## MMC Visitor Garage and East Tower Project - Final Traffic Comments

Hi Jean – the following outlines my Final Traffic comments as a status update of my January 18, 2018 initial review.

CONSTRUCTION ACCESS GATE

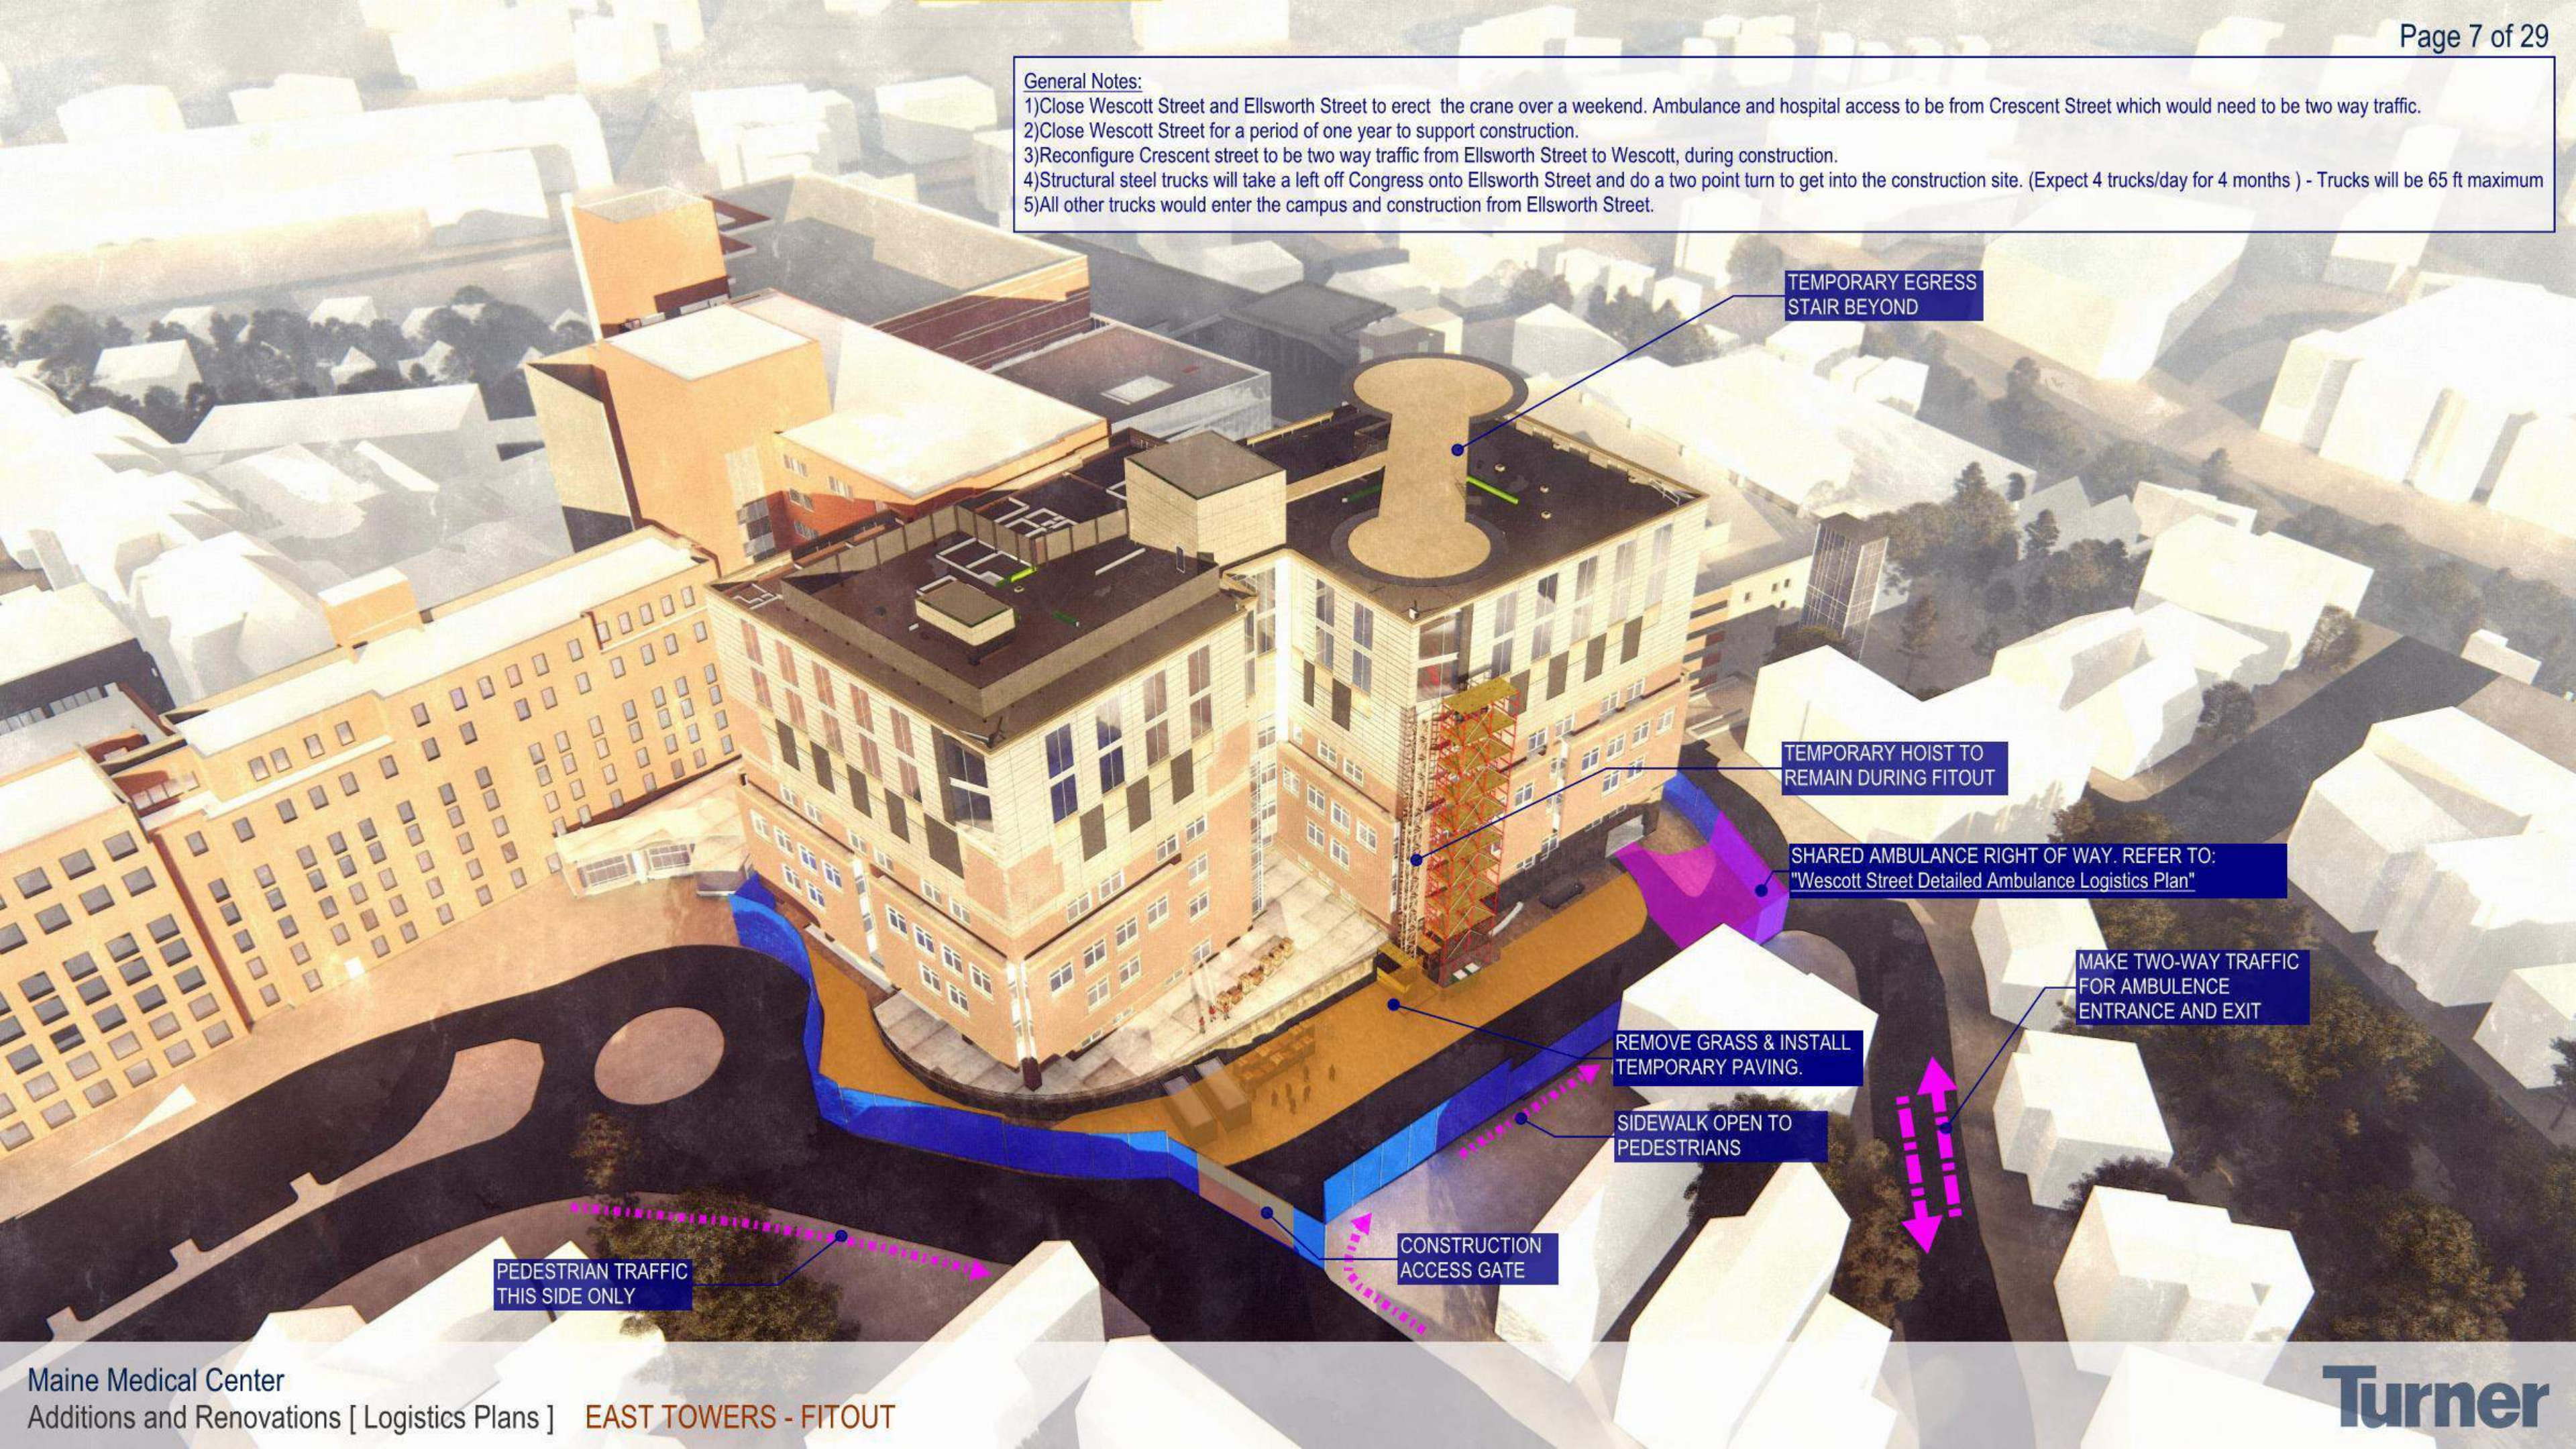
- The following are initial East Tower Traffic Control Plan comments:
  - The City does not support the conversion of Ellsworth Street to two-way flow between Congress Street and Crescent Street. The applicant has noted this to be acceptable. The plans should be revised to reflect this change.
  - It is unclear if the bump out at the Crescent Street/Wescott Street intersection is to be removed. If it is to remain, vehicle turning templates

should be provided for review and approval.

- Detailed routing and vehicle turning information for truck deliveries shall be provided for review and approval.
- It is my understanding that the Fire Department will be providing comments regarding concerns for Emergency Department vehicle access.
- Specific parking information shall be provided as it relates to fully understanding current on-street parking usage, location of on-street parking prohibitions, and how existing properties parking needs will be addressed given loss of on-street spaces.

**Status: Significant review and coordination has occurred in conjunction with the Construction Management Plan including vehicle/truck detours during the closure of Congress Street. I find the current plan to be acceptable with the noted Conditions of Approval.**
